REFUSAL OF PLANNING PERMISSION

APPLICATION NO. 2019/0210

Proposal Erection of dormer window extension on front roof plane (Retrospective)

At 16 Strafford Walk, Dodworth, Barnsley, S75 3RB

DRAWING
Proposed Plans & Elevations

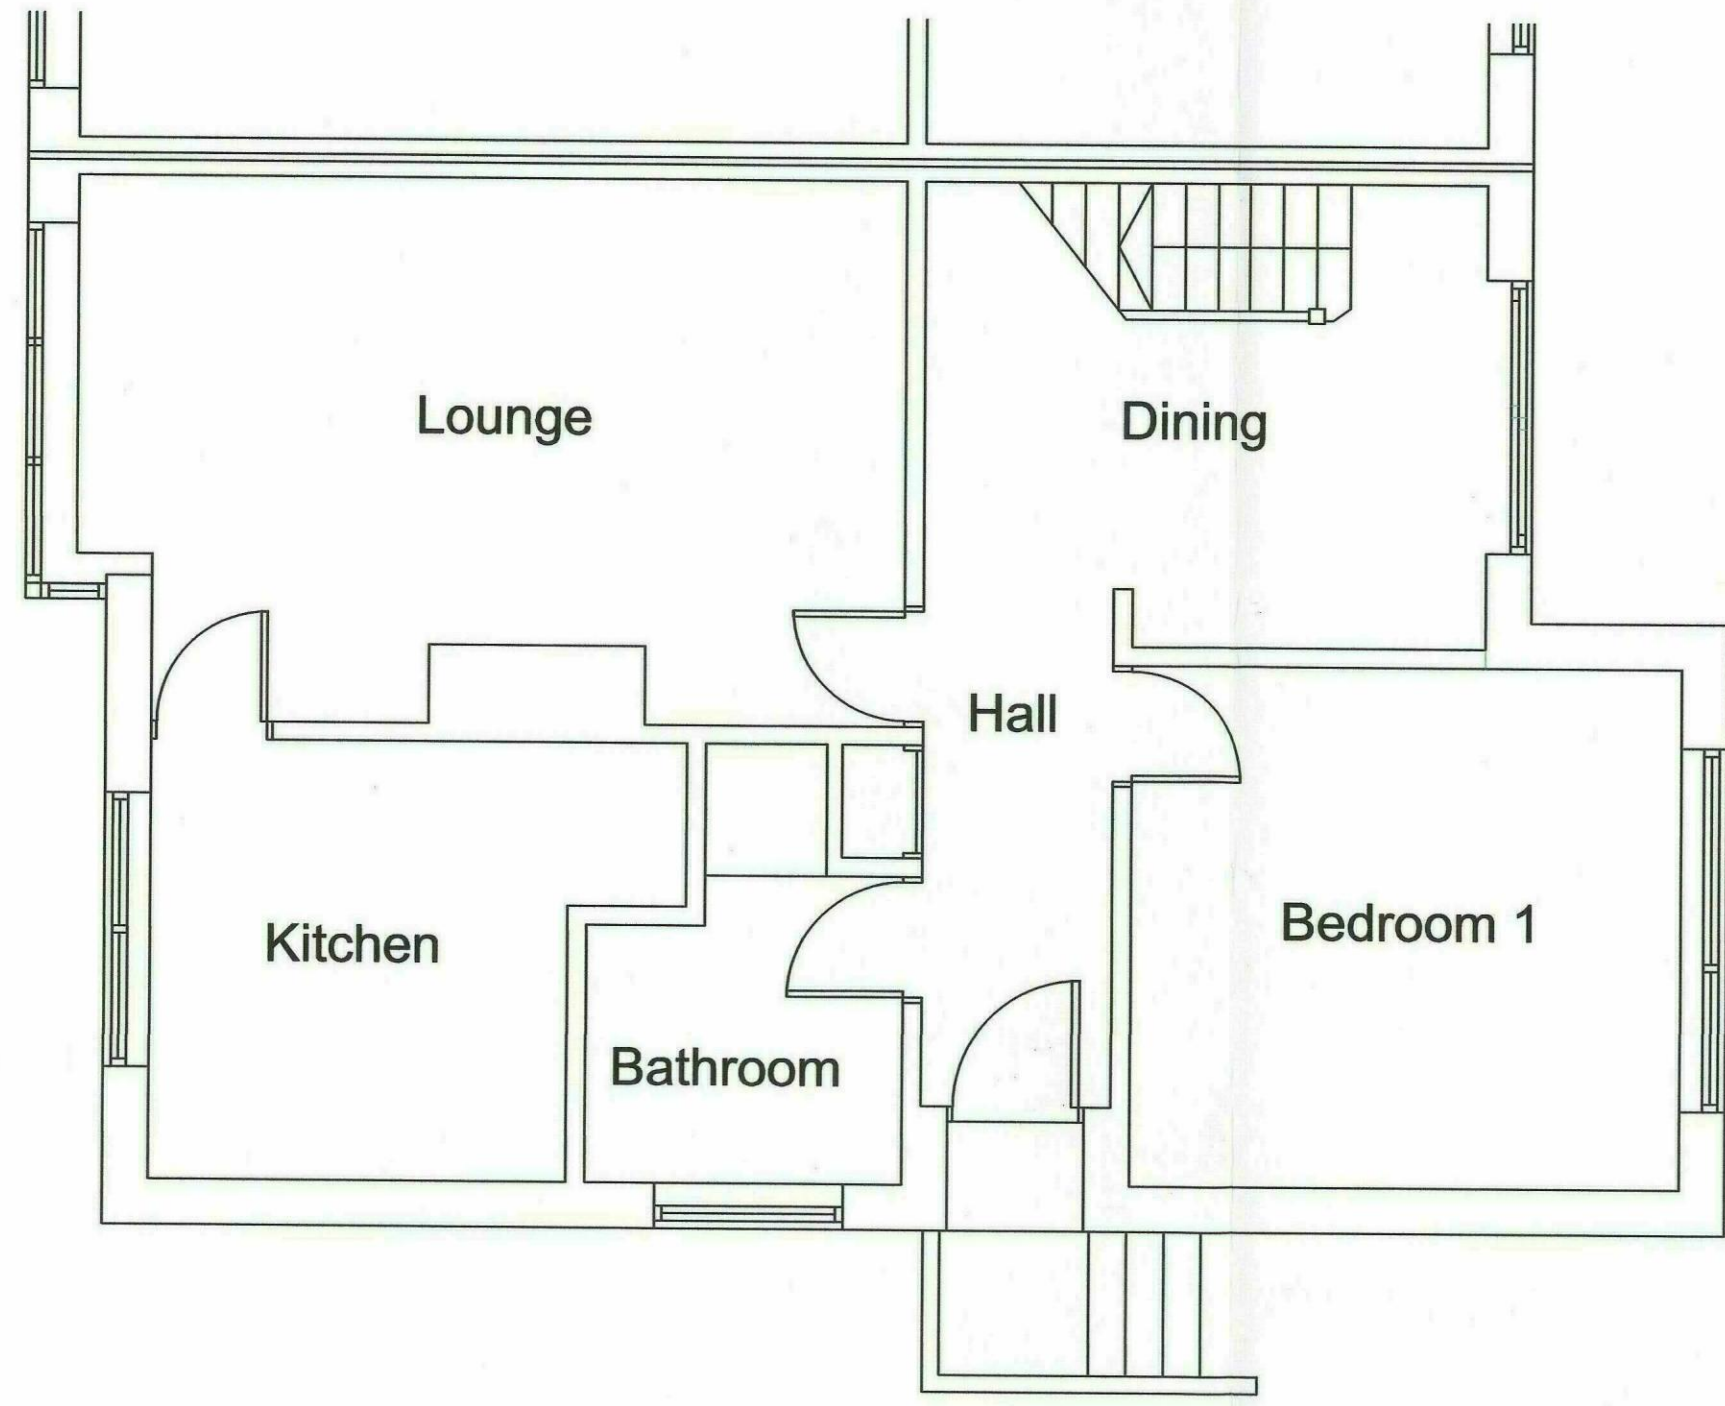
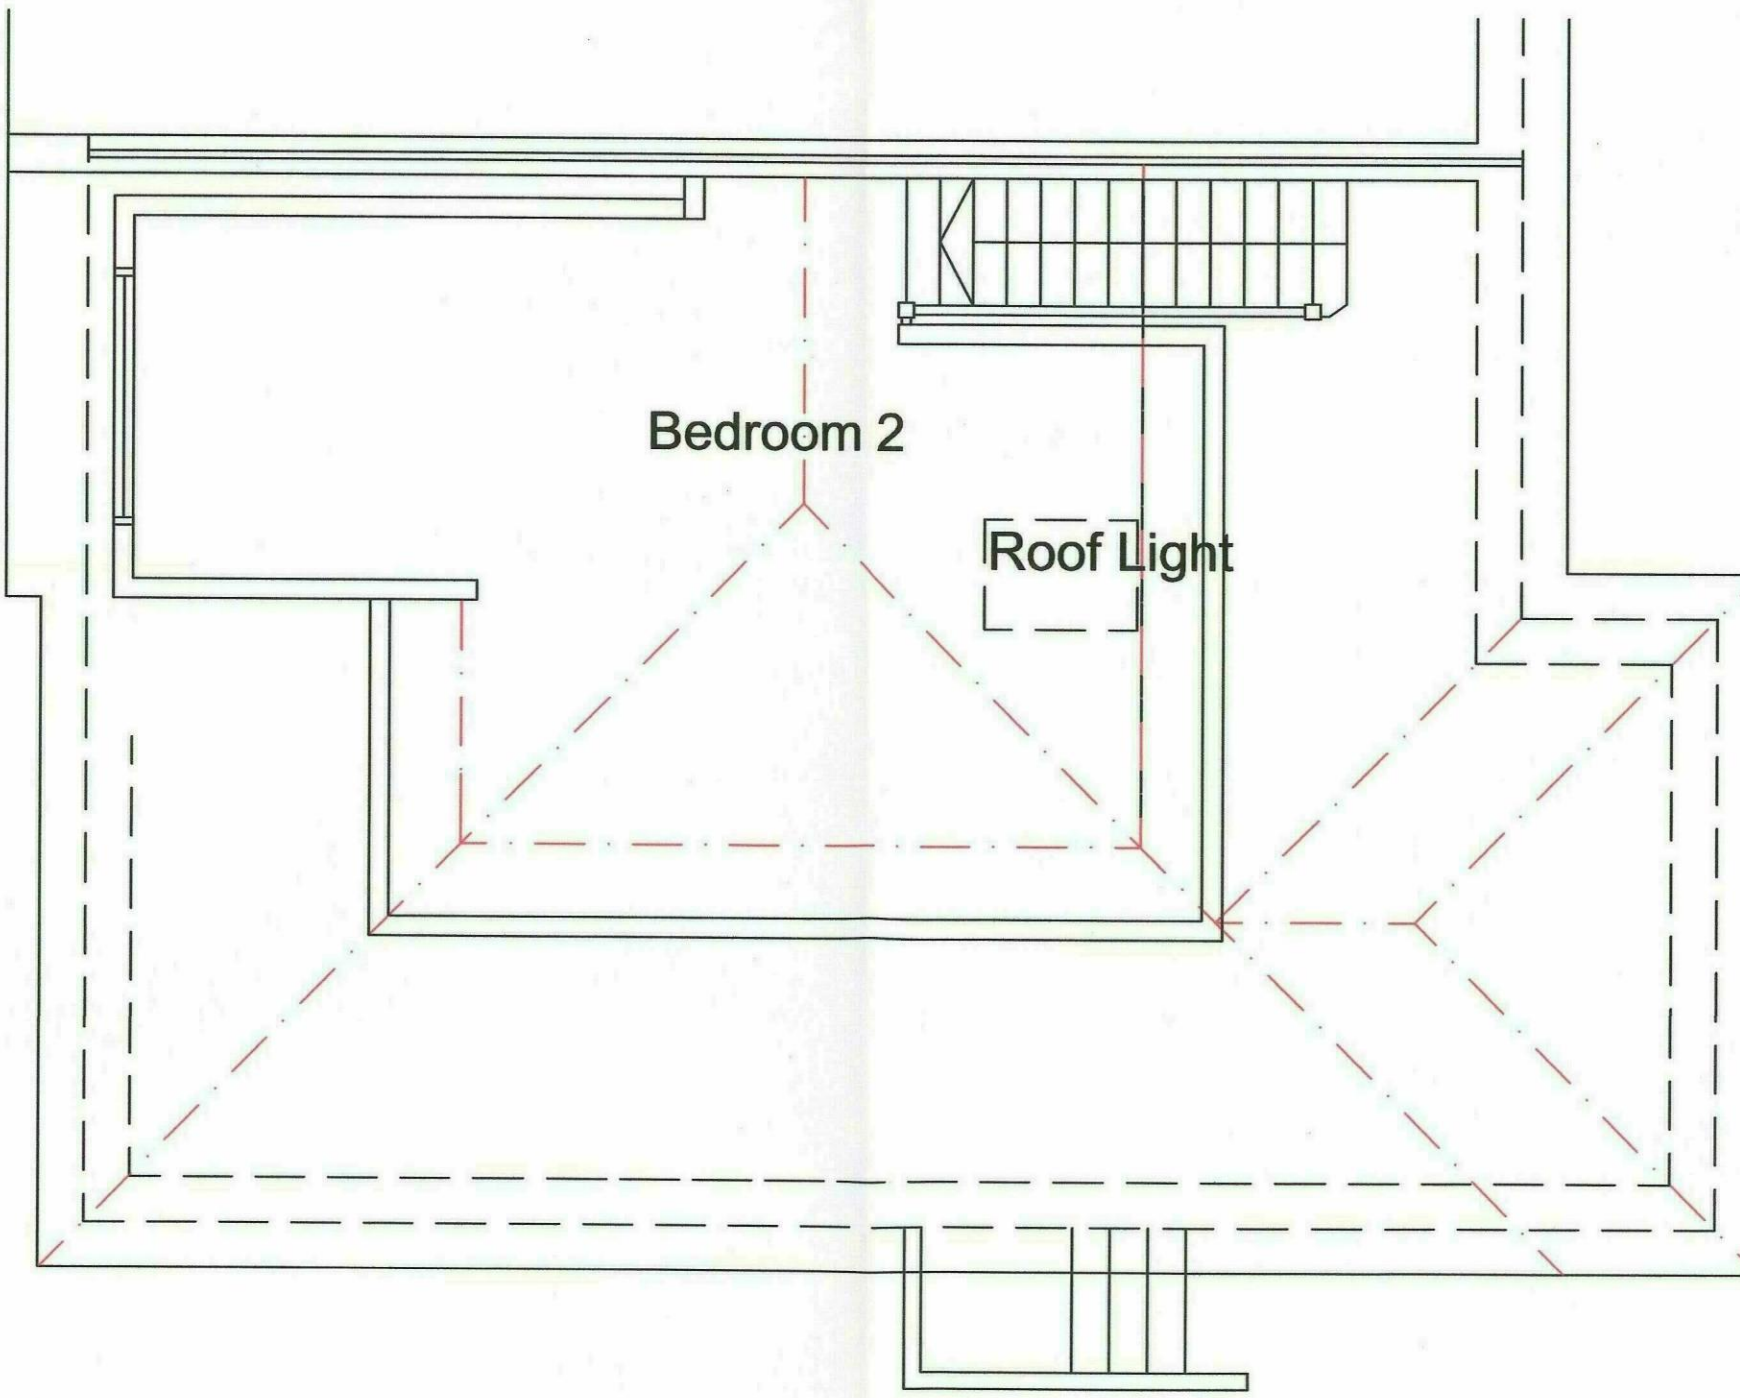
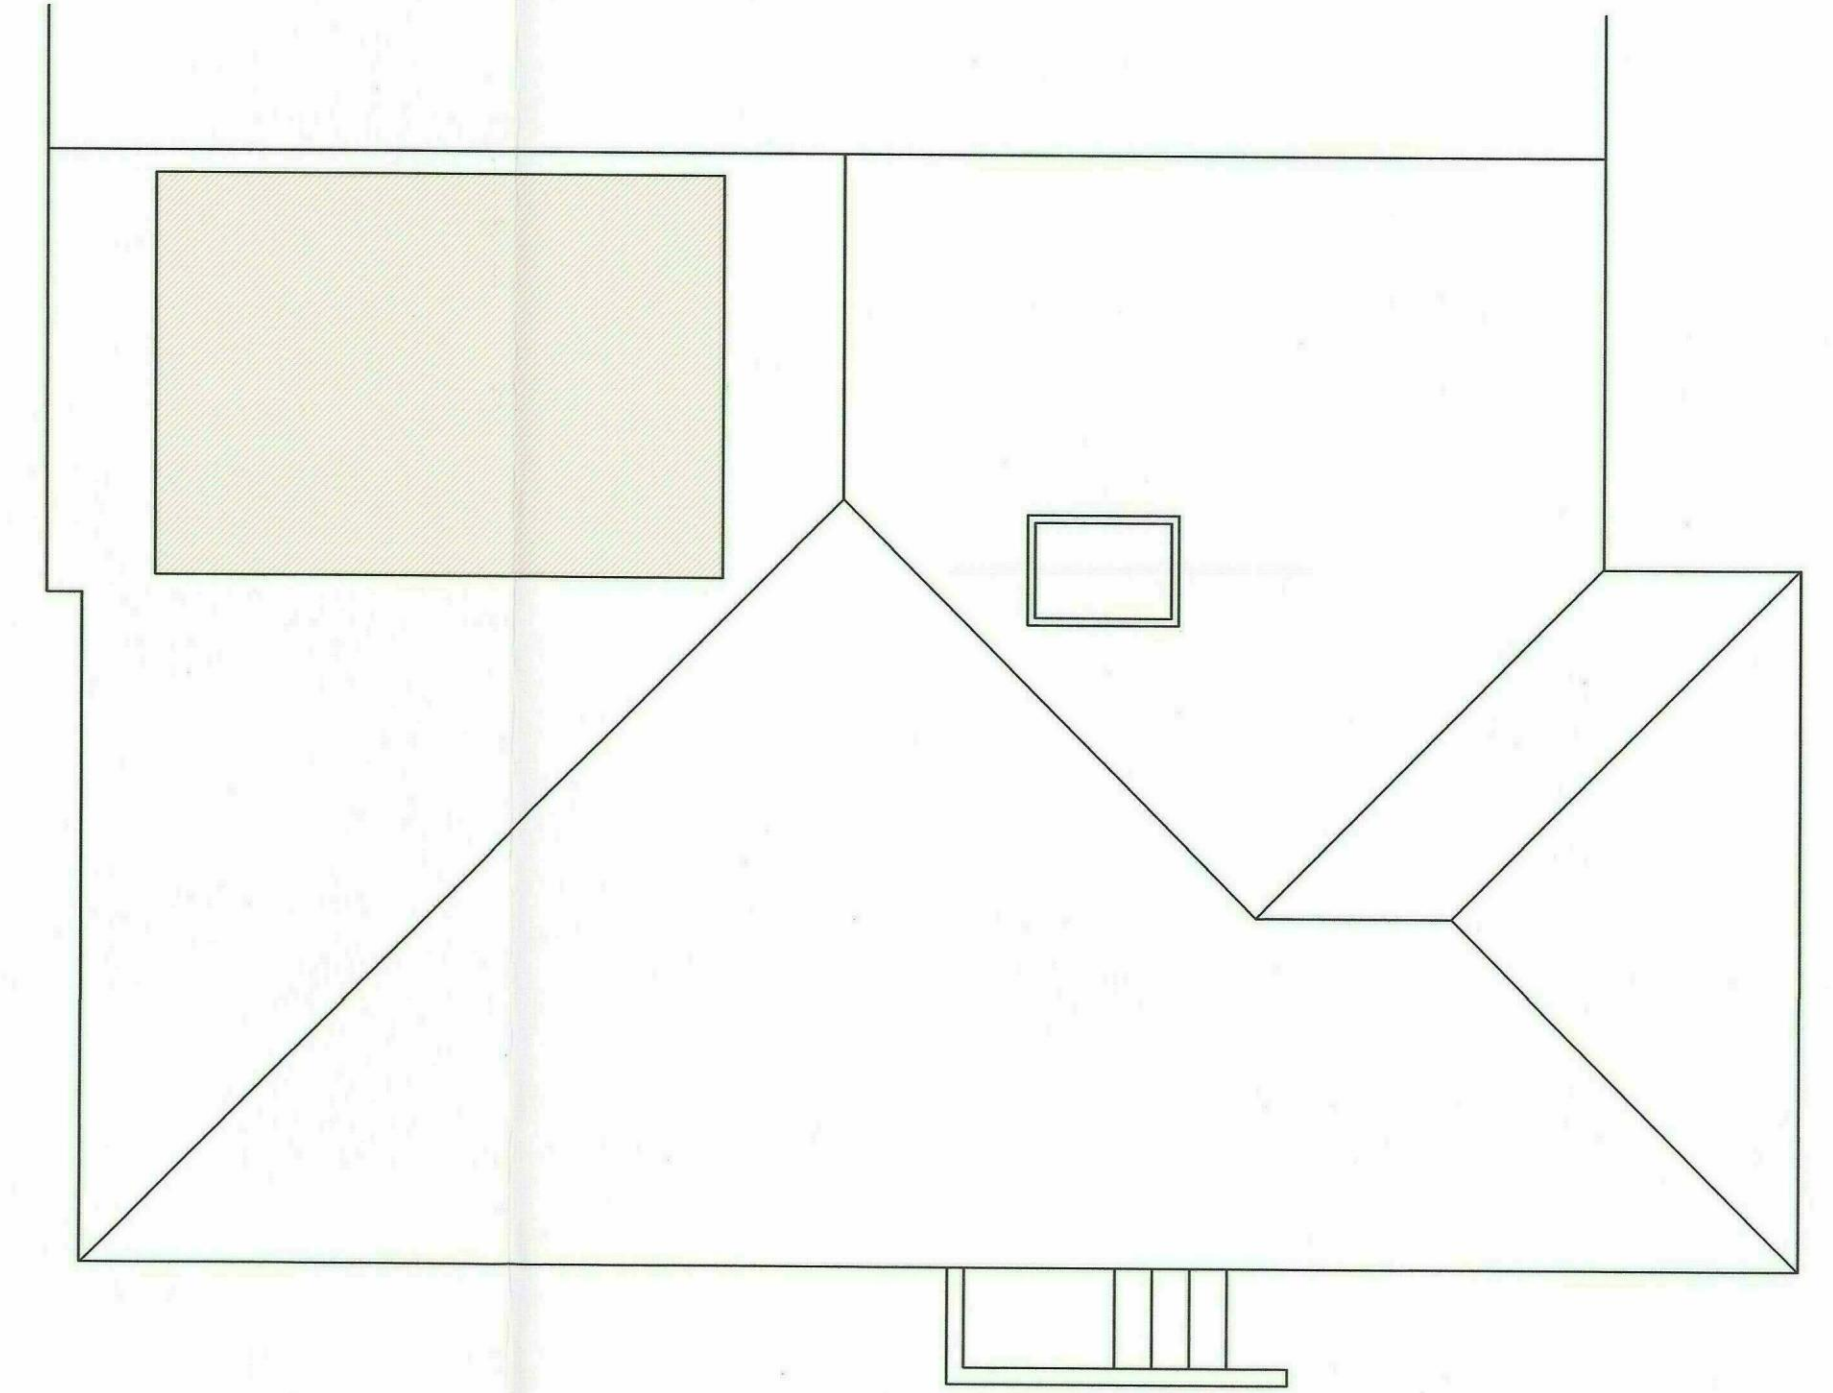
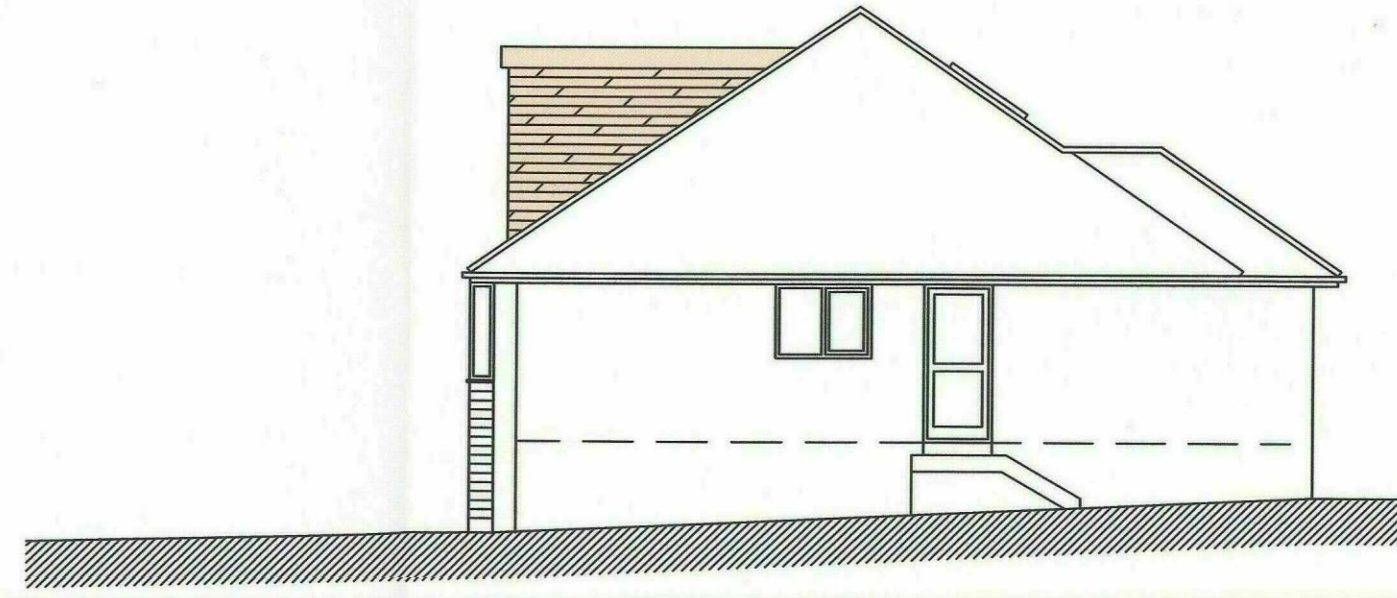
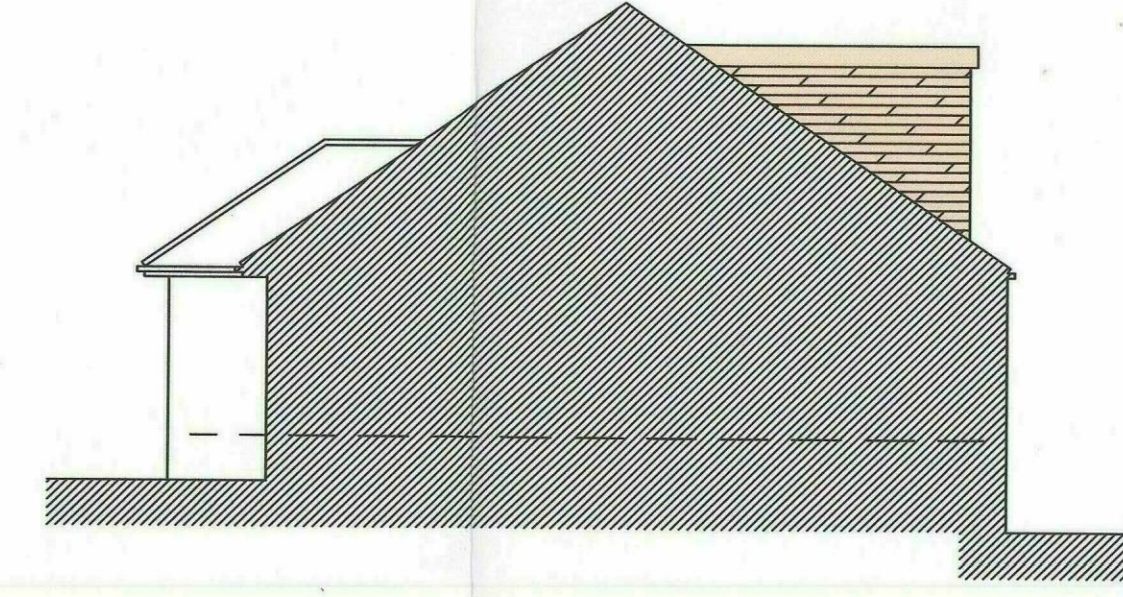
- 1 In the opinion of the Local Planning Authority the proposed dormer extension on the front elevation of the property is considered to be inappropriate and incompatible to its context, being of excessive scale and a design which does not harmonise with the existing bungalow adversely impacting on its appearance. Furthermore, its material construction detracts from the appearance of the property and, as a consequence, appears as an unduly intrusive feature in the street scene to the detriment of visual amenity. As such, the proposal is contrary to Local Plan Policy D1- High Quality Design and Place Making and the Council's Supplementary Planning Document - House Extensions.
